Appeal Decision

Appeal Ref: APP/R5510/W/23/3318295

35 Bedford Avenue, Hayes UB4 0DP

- The appeal is made under section 78 of the Town and Country Planning Act 1990 against a failure to give notice within the prescribed period of a decision on an application for planning permission.
- The appeal is made by Mr Setandar Junaja against the London Borough of Hillingdon.
- The application Ref 64163/APP/2022/2894, is dated 15 September 2022.
- The development proposed is a ground floor side extension, first floor rear extension and a change of use from a house to two flats.

35 BEDFORD AVENUE HAYES UB4 0DP
 PLANNING PERMISSION APPLICATION
 SINGLE STOREY SIDE AND REAR TWO
 STOREY EXTENSIONS & CHANGE OF USE
 FROM SINGLE RESIDENCE TO TWO FLATS
 PROPOSED DIMENSIONED ROOM ARRANGEMENT
 DRAWING: CH/SUNNY/37 SCALE 1 : 100 at A3
 DATE 9th SEPTEMBER 2022.

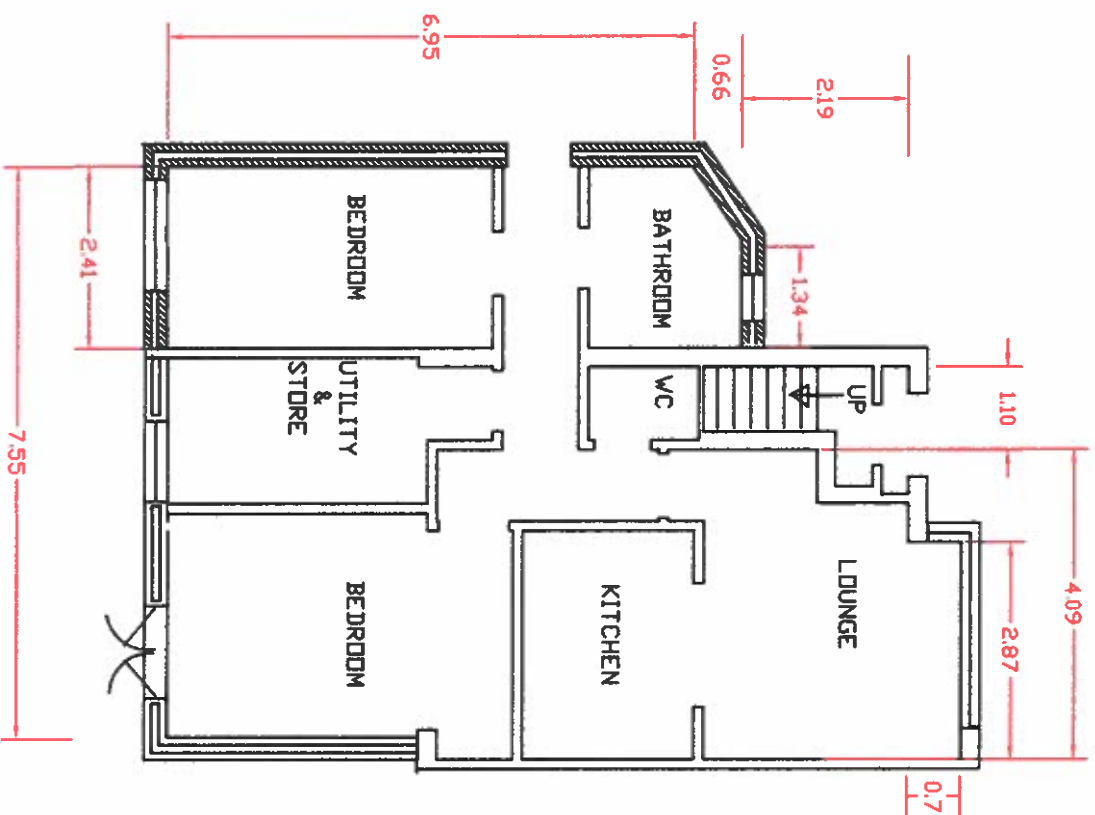
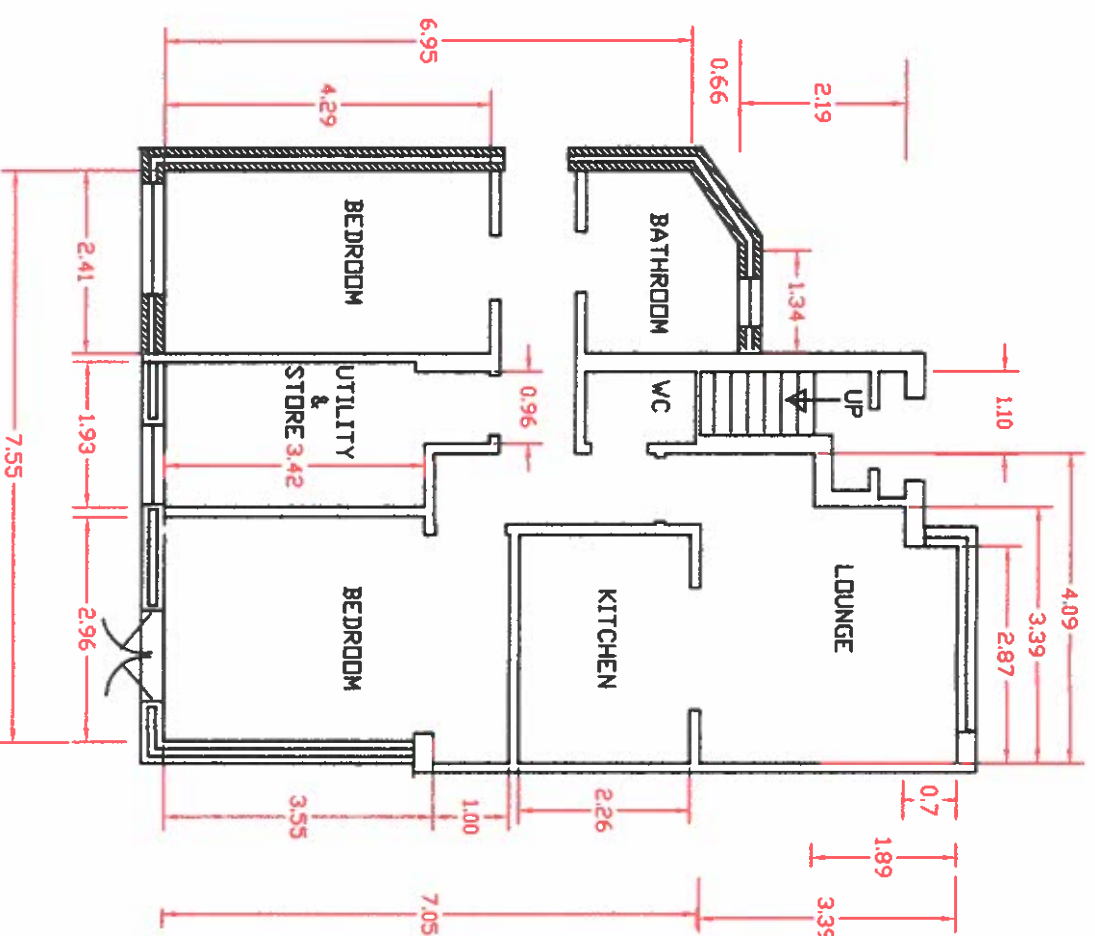
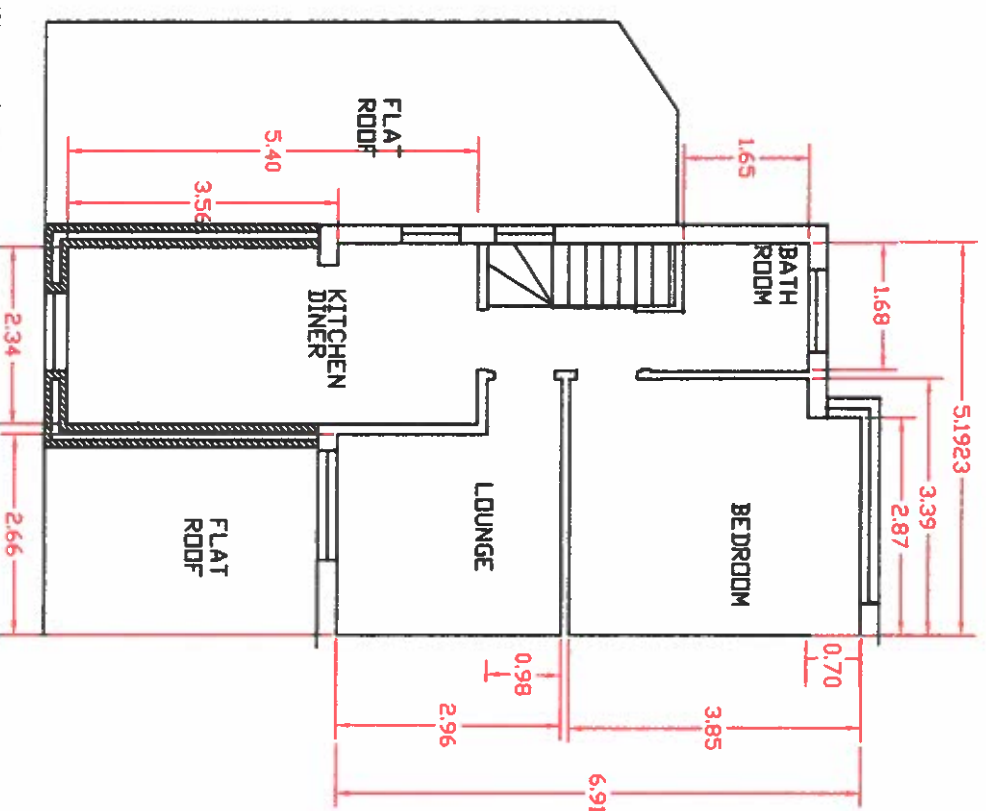
17. Policy DMHB 16 of LP2 states that all housing development should have an adequate provision of internal space in order to provide an appropriate living environment. To achieve this all residential development or conversions should meet or exceed the most up-to-date internal space standards as set out in Table 5.1. The standards in Table 5.1 are the same as those in Table 3.1 of policy D6 of the London Plan 2021. Those include the advice that a one storey dwelling with 1 bedroom 2 person occupancy as is the case for this appeal proposal should provide a gross internal area of at least 50sqm. The first floor flat would provide less than 50sqm GIA and so would fail to meet that standard by more than a small margin.
